From: Charlotte Bodin [mailto:Charlotte.Bodin@hhs.gov]
Sent: Tuesday, December 4, 2018 1:26 PM
To: Carl Moore [mailto:Carl.Moore@hhs.gov]
Subject: RE: Further Information Required on Your Ref: PP-07443189 Our Ref: EP/173/18/HH

Date:	Scales:	Paper size:	Dwg No.:
Nov 2018	As shown	A3	AR-133-03

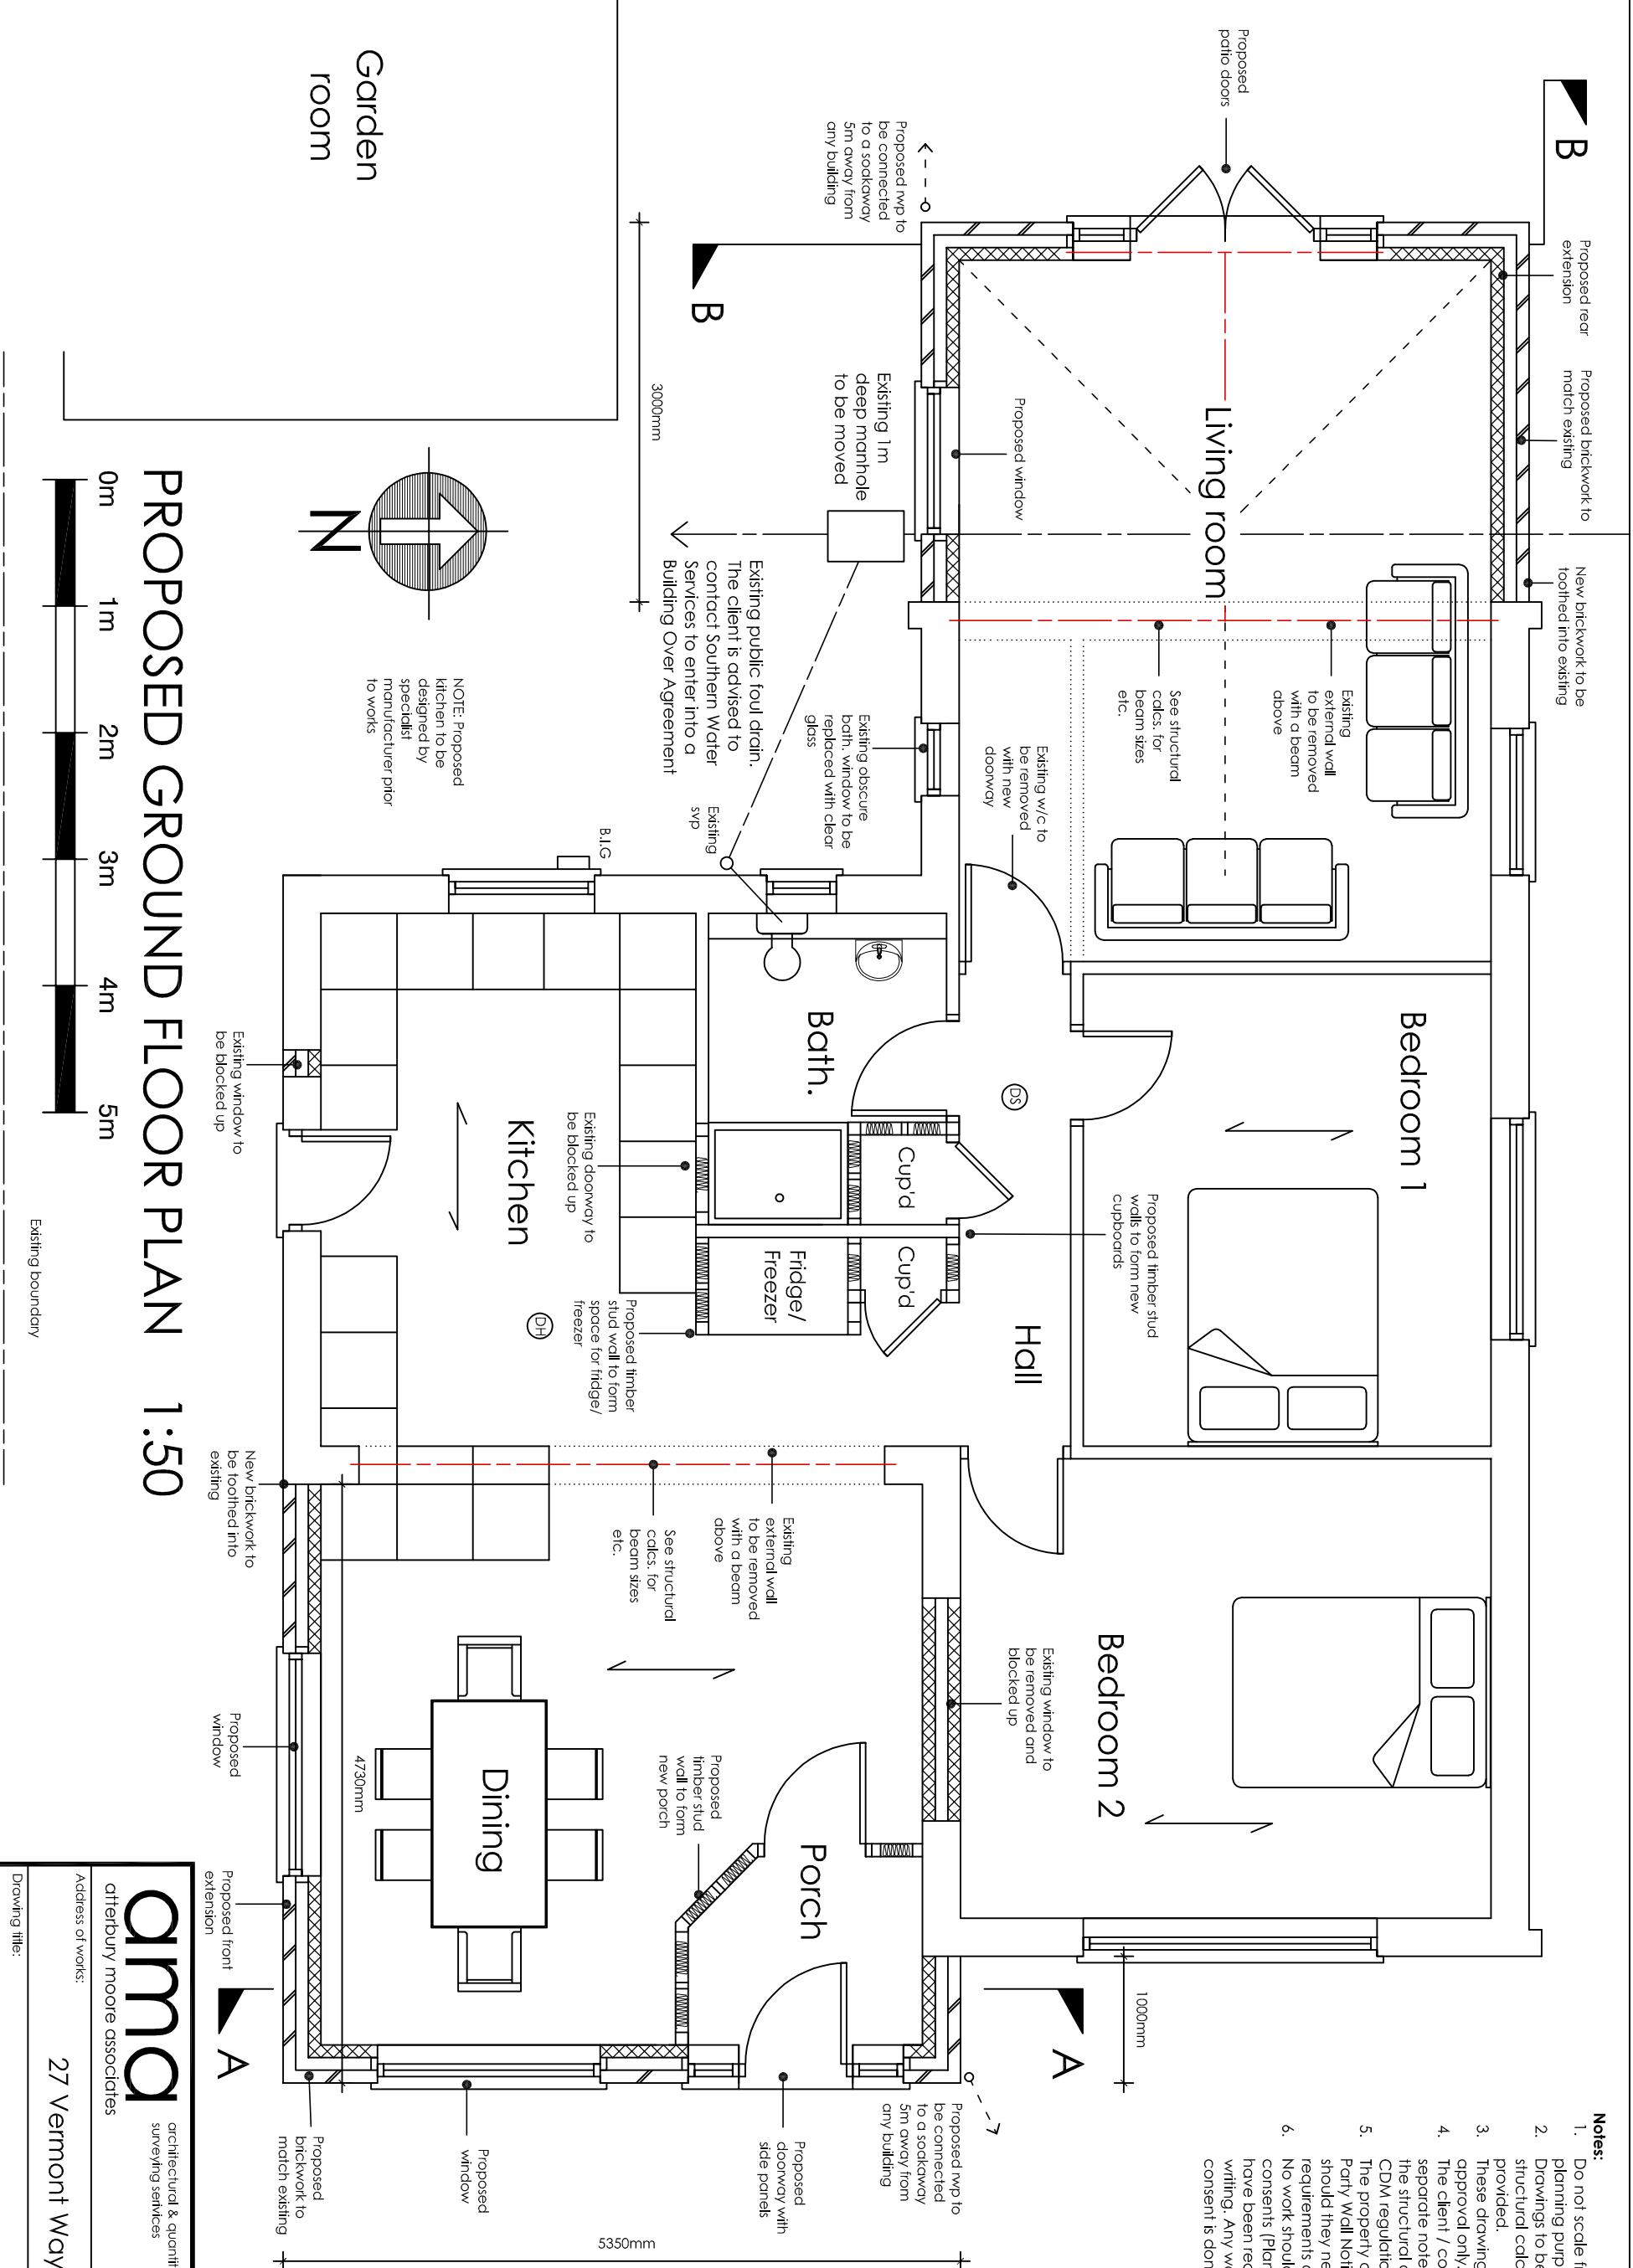
Thank you for your email. Please see below screenshot which will hopefully clarify. This has been shown on the existing and proposed floor plans and the existing elevation, however is not shown on the proposed north elevation.

Please find attached a revised site plan showing the distances from boundaries as requested. With regard to your second point, please could you clarify the discrepancy with the elevations. Please note that the proposed side elevation from the north includes the 1.0m front extension that can be seen from the north.

Please find attached a copy of the revised elevations with the pier included.
